City of Portland, Maine - Building or Use Permit Application

Permit No: 06-0998	Issue Date: PERMIT ISSUED JUL 26 2006	CBL: 065 A015001
--------------------	---	------------------

Location of Construction: 959 CONGRESS ST	Owner Name: KEY LLC	Owner Address: 50 PORTLAND PIER STE 400	Phone:
Business Name:	Contractor Name: Maine Banner & Decal Co.	Contractor Address: 16 Bonnie Ave CITY OF PORTLAND	Phone: 2074654200
Lessee/Buyer's Name	Phone:	Permit Type: Signs - Permanent	Zone: B2

Past Use: Commercial - Mercy Hospital Face River Urology	Proposed Use: Commercial/ new signage- 3- 30" x 96" signs	Permit Fee: \$150.00	Cost of Work: \$150.00	CEO District: 2
		FIRE DEPT: <input checked="" type="checkbox"/> Approved <input checked="" type="checkbox"/> Denied N/A	INSPECTION: Use Group: U Type: Sign IBC 2003

EXHIBIT A

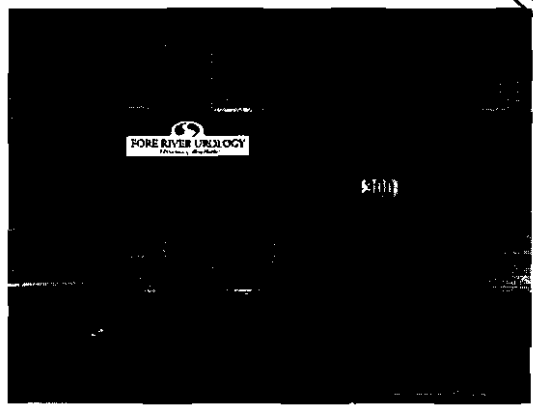
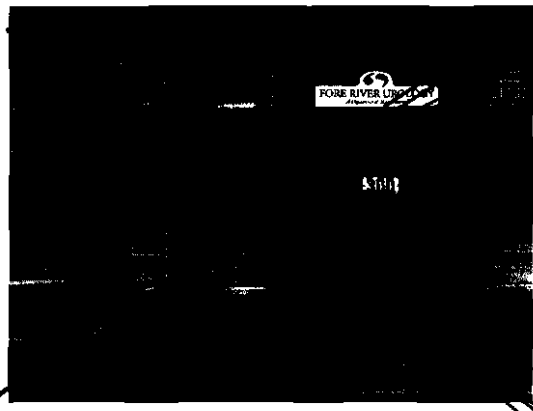
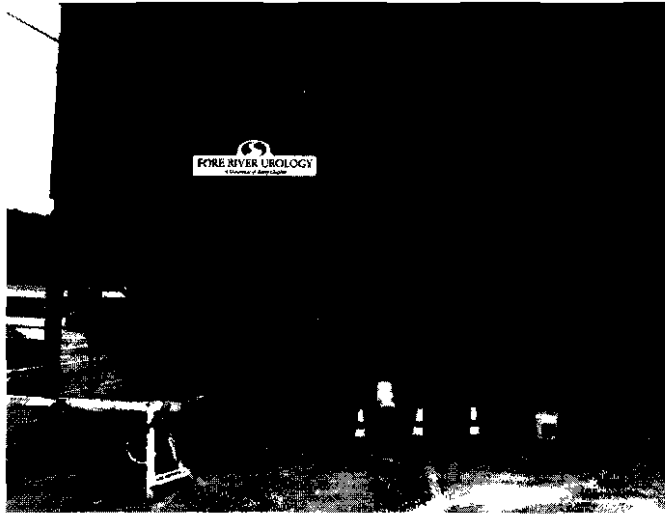
7/14/06-amachado: Left message for Bob Mastison. Can't do three signs. Need more information on the size of the sign.

7/14/06-amachado: Bob left message. Dimension given for sign includes the semis circle above the name.

7/17/06-amachado: Vivcki Sullivan from Mercy Hospital is asking planning to approve the three signs instead of the two that is allowed for a multi-tenant building in the B2.

1) Signage Installation to comply with Chapter 31 of the IBC 2003 building code.
